CITY OF ALBUQUERQUE

November 6, 2020

**Re: Place at Nob Hill
3339 Central SE 87106
30-Day Temporary Certificate of Occupancy
Transportation Development Final Inspection
Engineer's/Architect's Stamp dated 9-11-19 (K16D069)
Certification dated 11-3-20**

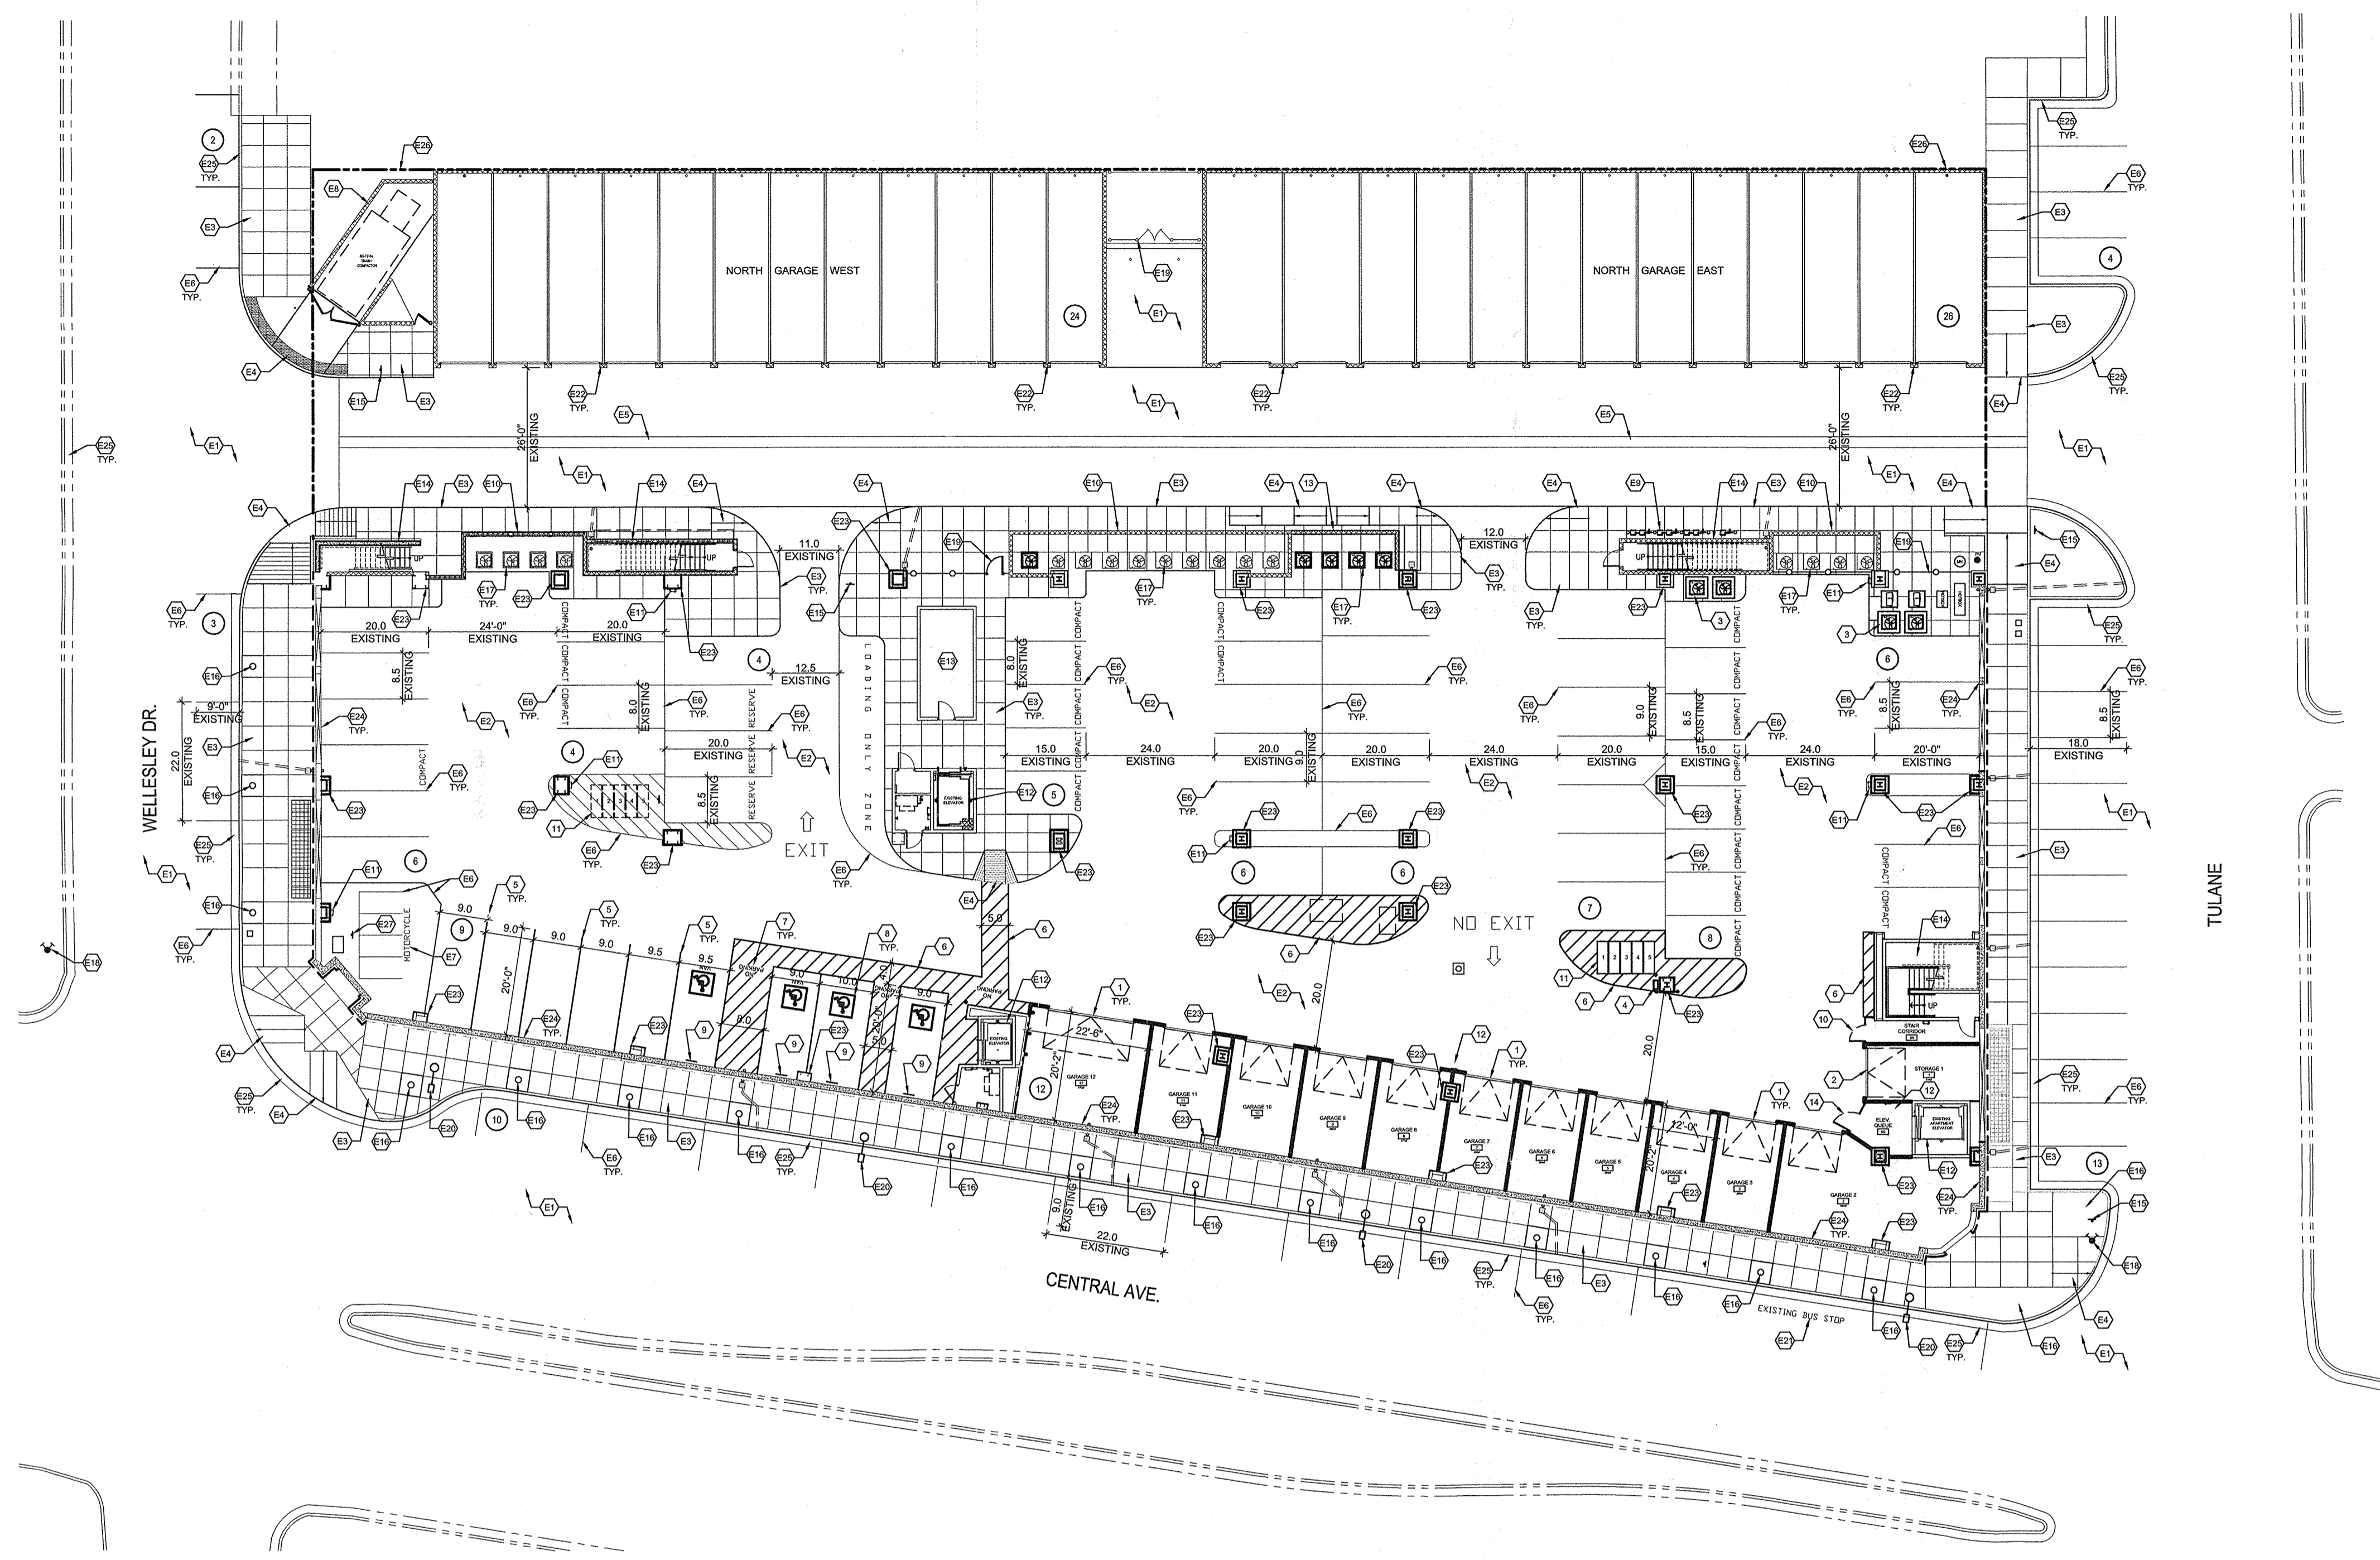
- Please add Motorcycle Parking & Motorcycle Parking Signs.
- Please update ALL ADA Parking Signs. The ADA accessible parking sign must have the required language per 66-7-352.4C NMSA 1978 "**Violators Are Subject to a Fine and/or Towing.**" If that language is present it is not visible in the detail.

Once these corrections are complete, email pictures showing the changes to PLNDRS@cabq.gov, and epgomez@cabq.gov for release of Final CO
